Application No: WA/93/20/PL
Site Address: Land East of Tye Lane Walberton BN18 0LU
Description of works: Alternative vehicular access off Tye Lane & emergency access off Avisford Park Road, along with minor highway works following WA/95/18/RES. This site is in CIL Zone 2 (Zero Rated) as other development.

Thank you for your internet representation made on 15th April 2021 which has been recorded as an objection with the comments as follows:

AVISFORD PARK ROAD

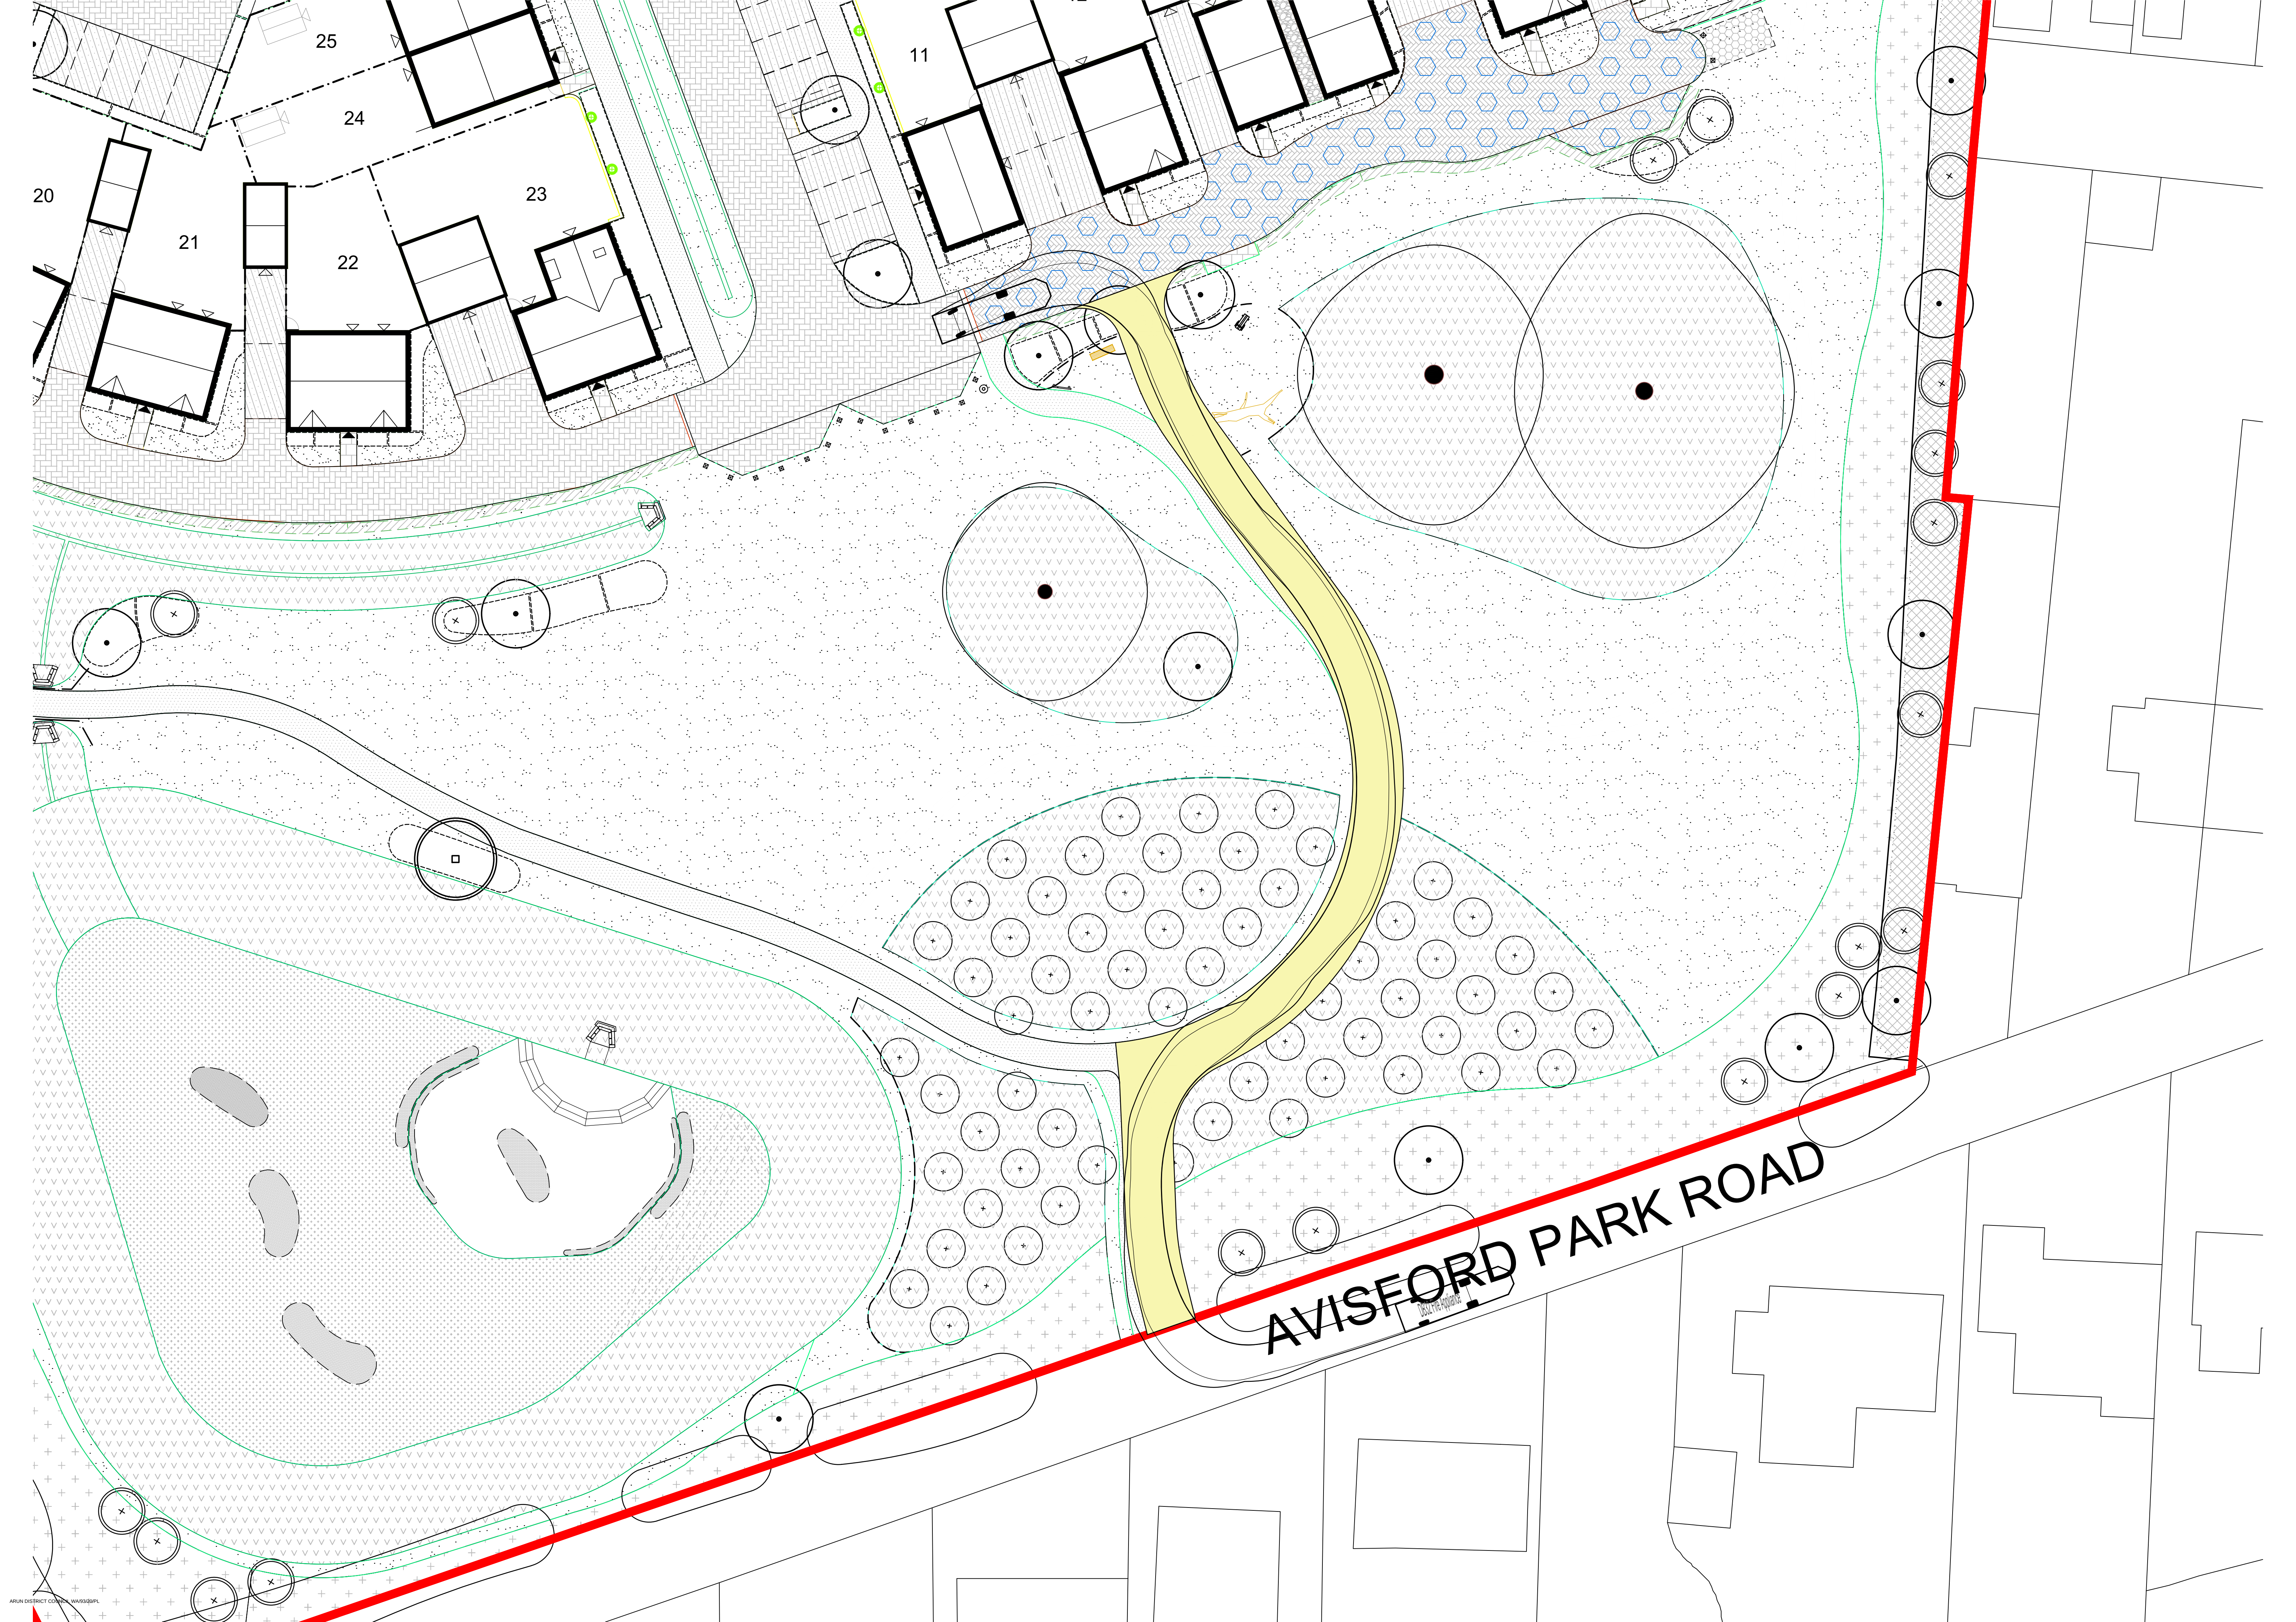
We strongly object to this application. Whilst not affected by the main access road, the proposal to have the emergency access into Avisford Park Road makes no sense on many levels.

The area of green and pond (the newly designated community parkland) created for wildlife/recreation as part of the original development will now be reduced because of the building of this road. This is reneging on the conditional approval of the original plans. Does establishment of this road and entrance set a precedent for future development on the green area?

This entrance will lead to the loss of safety for residents, walkers, dogs, cyclists and children walking home from school all of whom use the footpath, which is a right of way along Avisford Park Road.

Will this gate be kept locked at all times when not in use for the emergency services?

Avisford Park Road is an unadopted road with a poor surface. There is not room for two vehicles to pass without one pulling into the side. It is not an appropriate road for an emergency vehicle which needs a smooth ride and to be able to travel at speed. The steep and narrow entrance to the road is also not suitable for emergency vehicles or more traffic than that generated by the houses already in the road. It would NOT be appropriate for other residents on the estate to be able to use Avisford Park Road as a regular entrance.
